21<sup>st</sup> February 2020

***Re: Response to Agency Comments on SSD5300 Mod2 - Kembla Grange Resource Recovery Facility***

**Table 1. Agency comments, and subsequent responses and actions are provided in Table 1 below.**

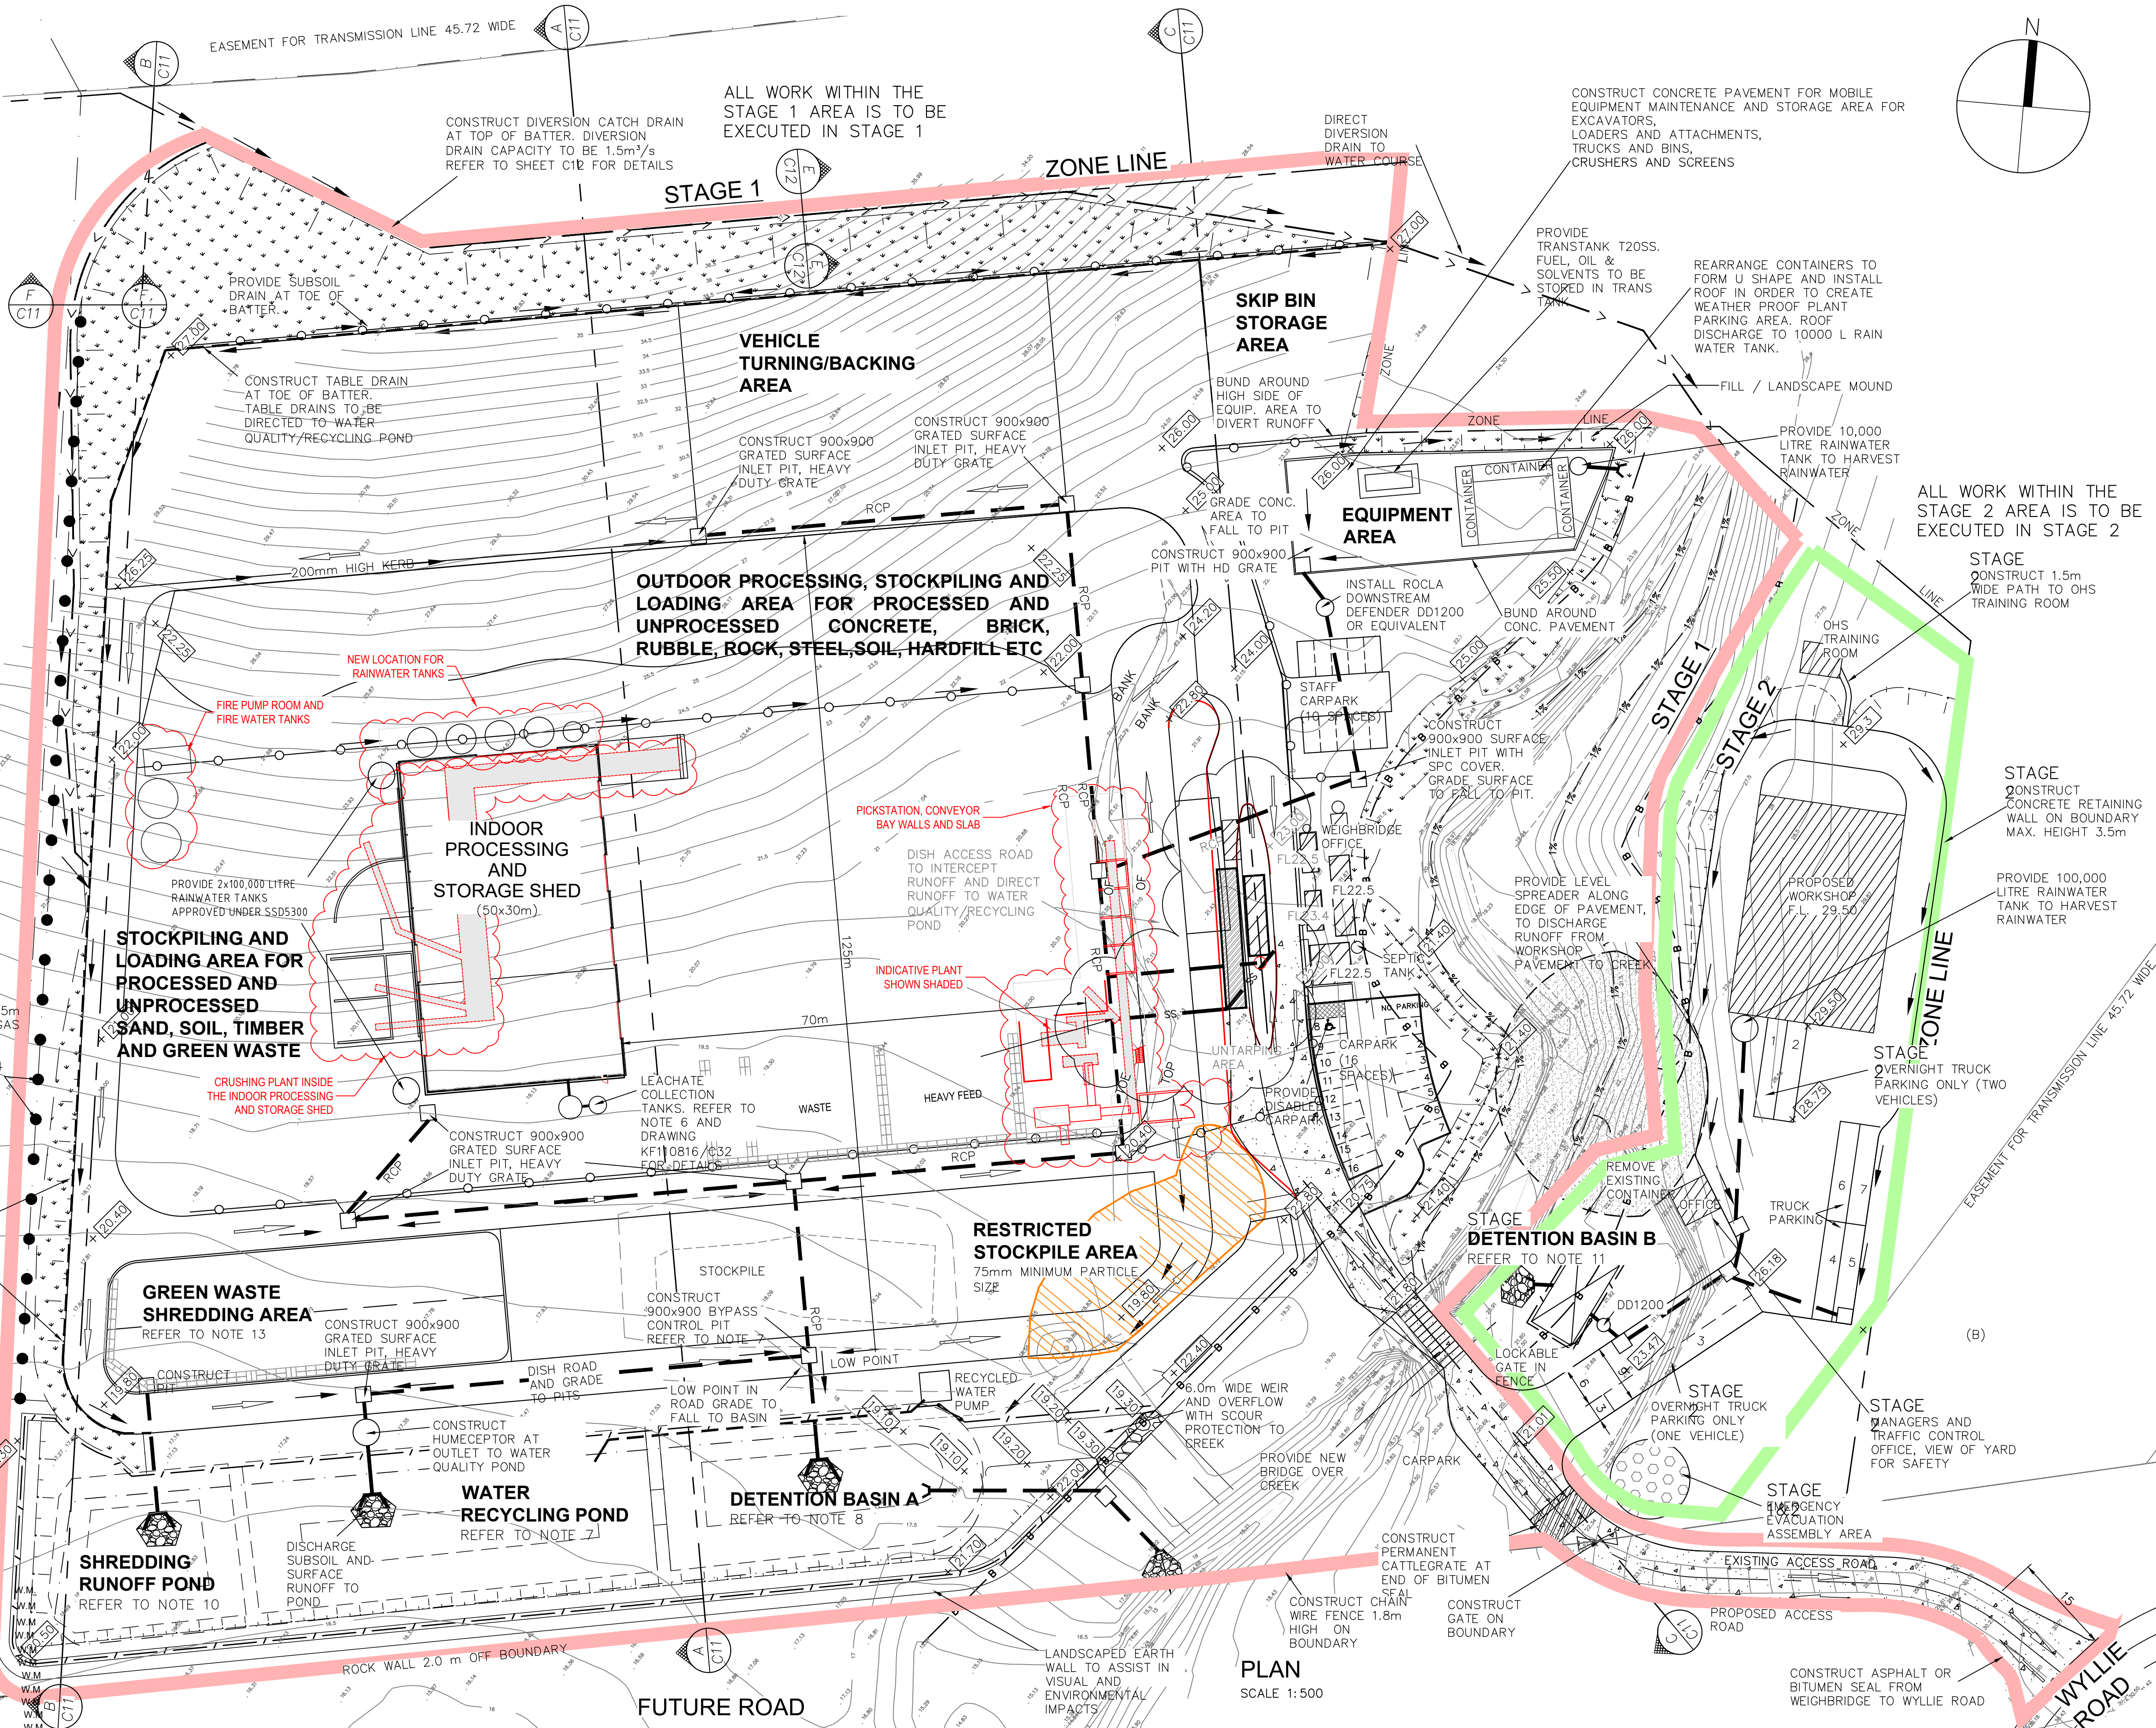
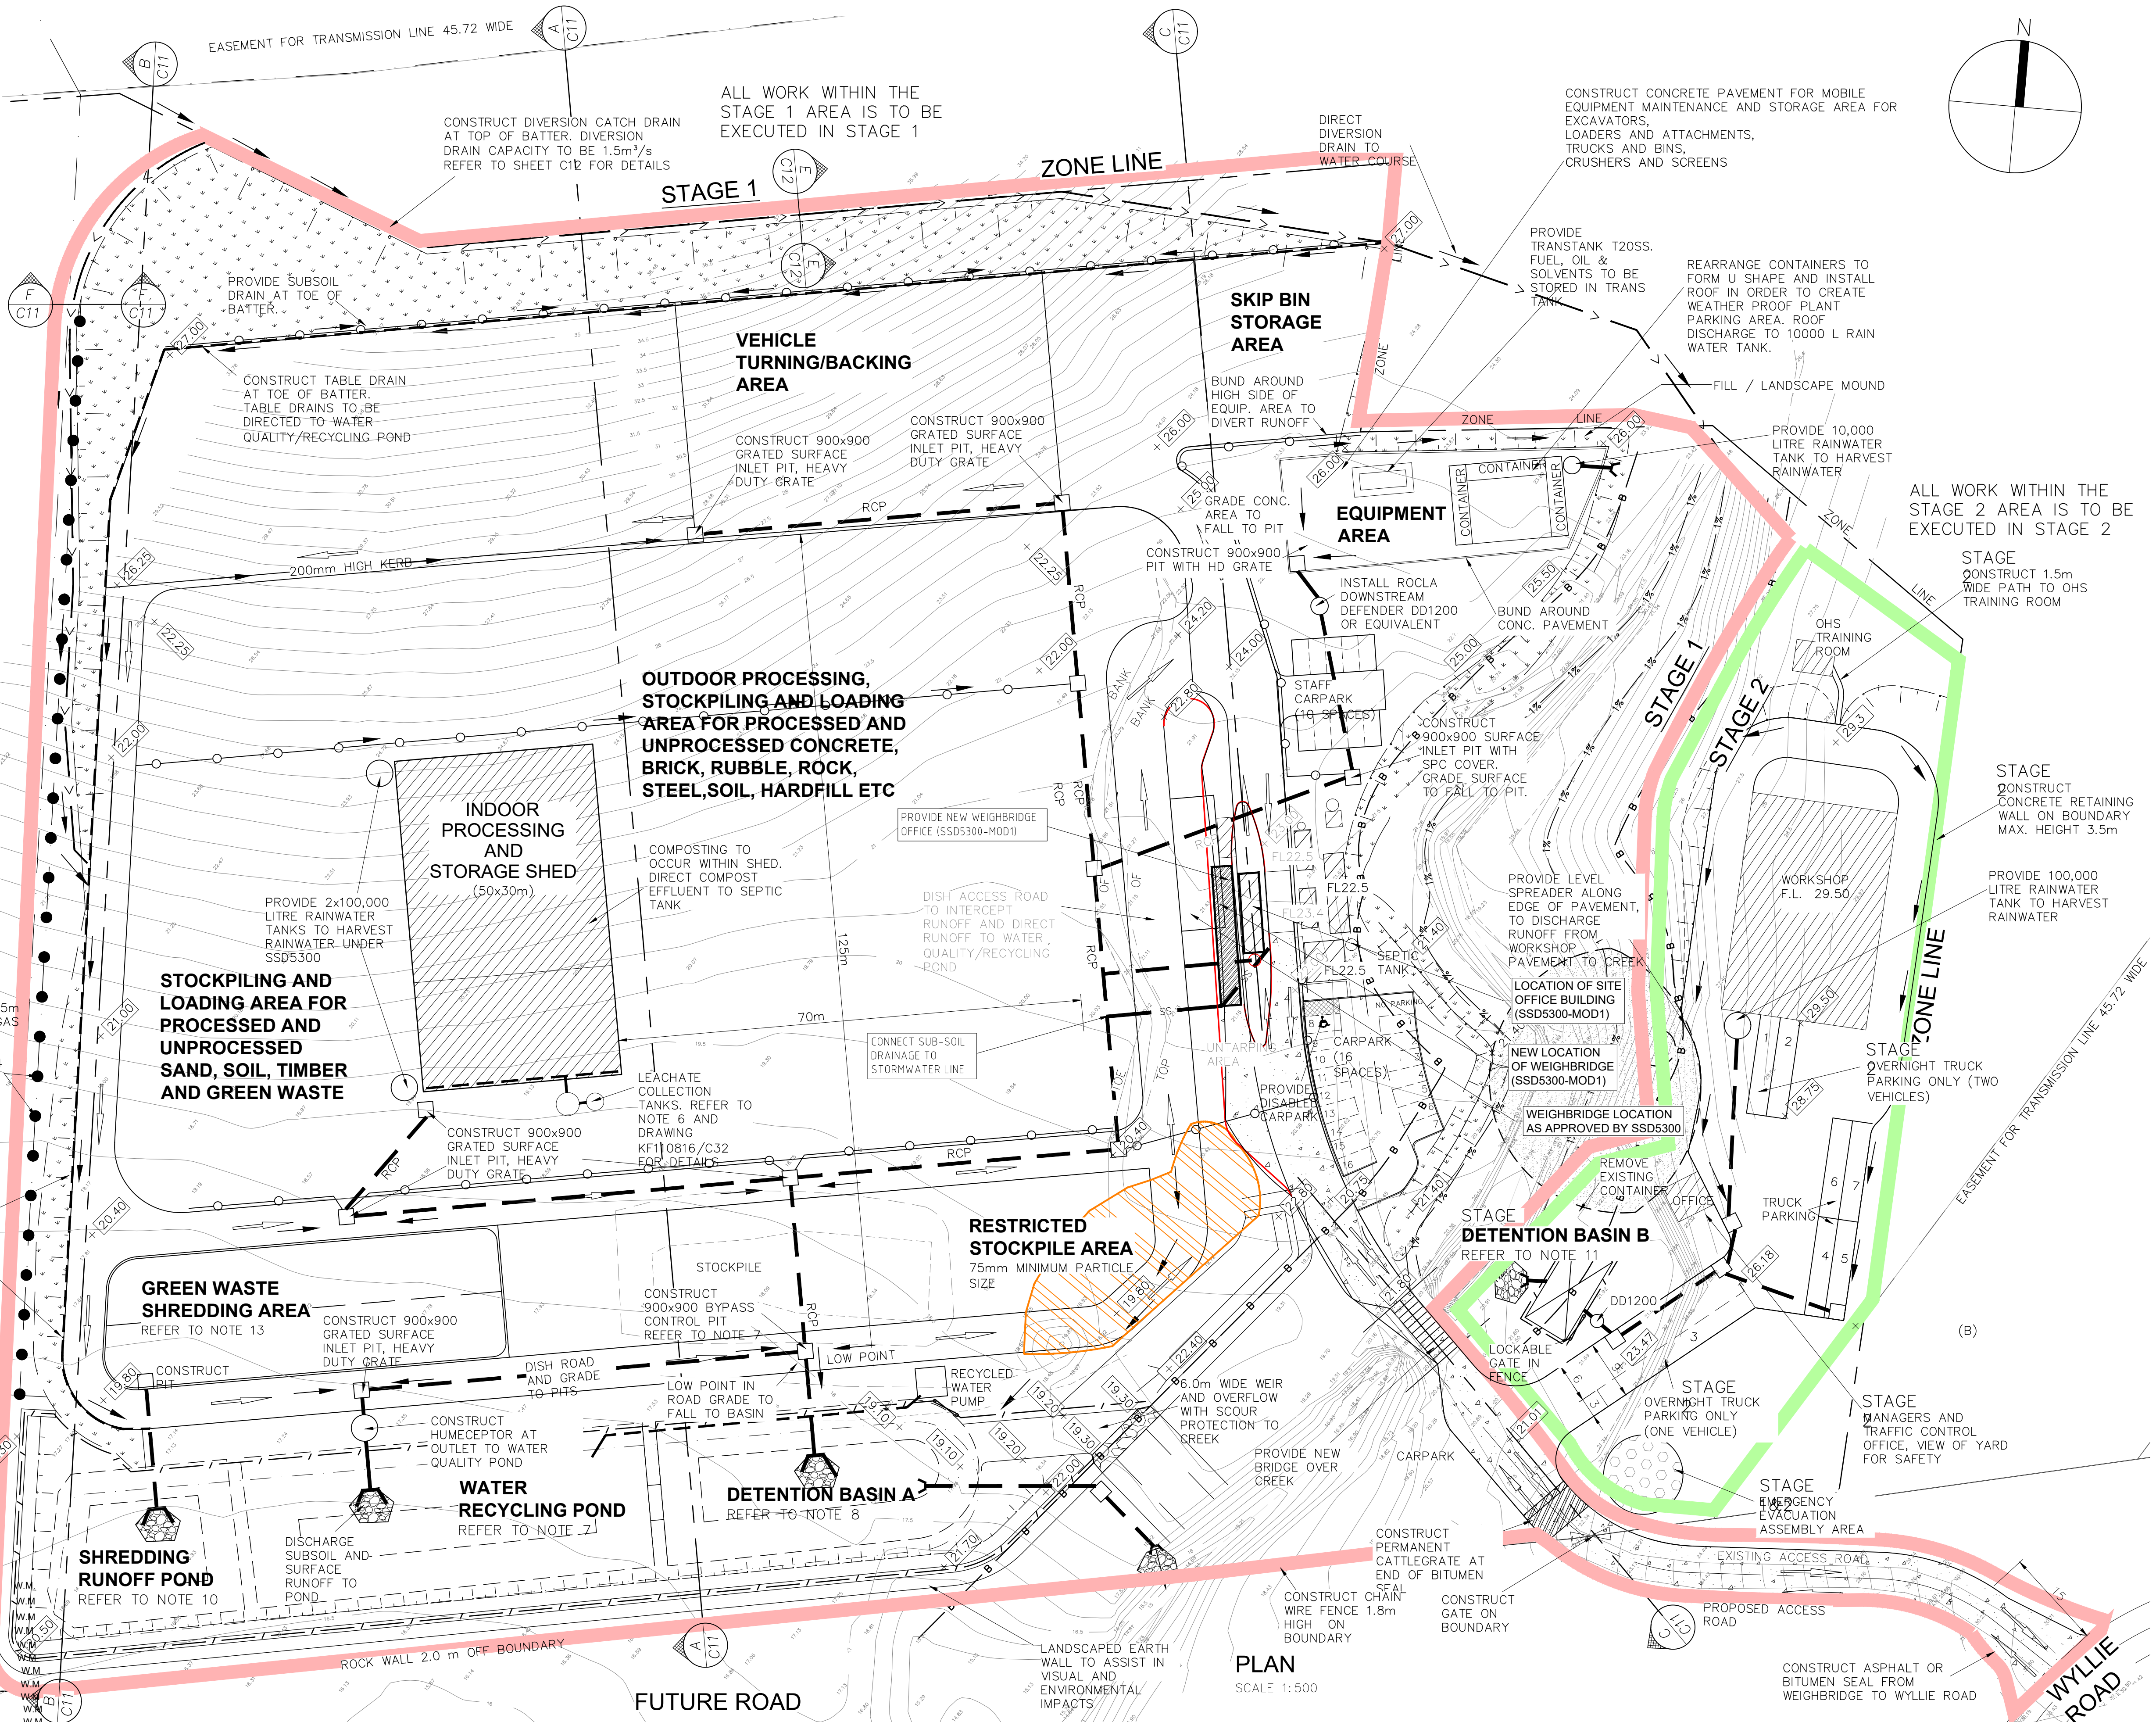
Agency	Comment	Response	Action taken or proposed Statement of Commitment
	<p>6. All segregated garden waste must be stored and processed in the area labelled "Green waste shredding area" on the drawing titled Proposed Industrial Development, Lot 10 DP 878167, Wyllie Road, Kembla Grange, Site Plan, Drawing No. C10 prepared by KFW and dated 7 November 2012.</p> <p>7. Waste must not be stored or stockpiled on any stormwater pit at the Premises.</p>	<p>The Applicant accepts this proposed condition.</p> <p>The Applicant accepts this proposed condition.</p>	<p>Section 2.11 has been updated to include a summary of the findings of the Water Impact Assessment.</p> <p>Proposed condition to reference updated drawing (Refer to RTS Appendix 3).</p> <p>Noted.</p>
Wollongong City Council	<p><b>1. Regularisation of unapproved works</b></p> <p>The modification seeks approval for a number of existing structures that situated on the subject site identified as: the rainwater storage tanks; firewater storage tanks and a pump room on the premises; and construction and operation of an outdoor picking station and associated processing equipment (including de-stoning screen and generator).</p> <p>It is noted that these structures are also associated with or located upon a concrete slab.</p> <p>Prior to granting consent to the use of these existing structures, it is considered evidence should be provided to demonstrate these structures are structurally sound</p>	<p>The Applicant accepts this proposed condition</p>	<p>A Structural Certificate and NCC Compliance Certificate for the rainwater storage tanks, firewater storage tanks, pump room and outdoor picking station has been included as Appendix 4a and 4b in the Statement of Environmental Effects.</p>
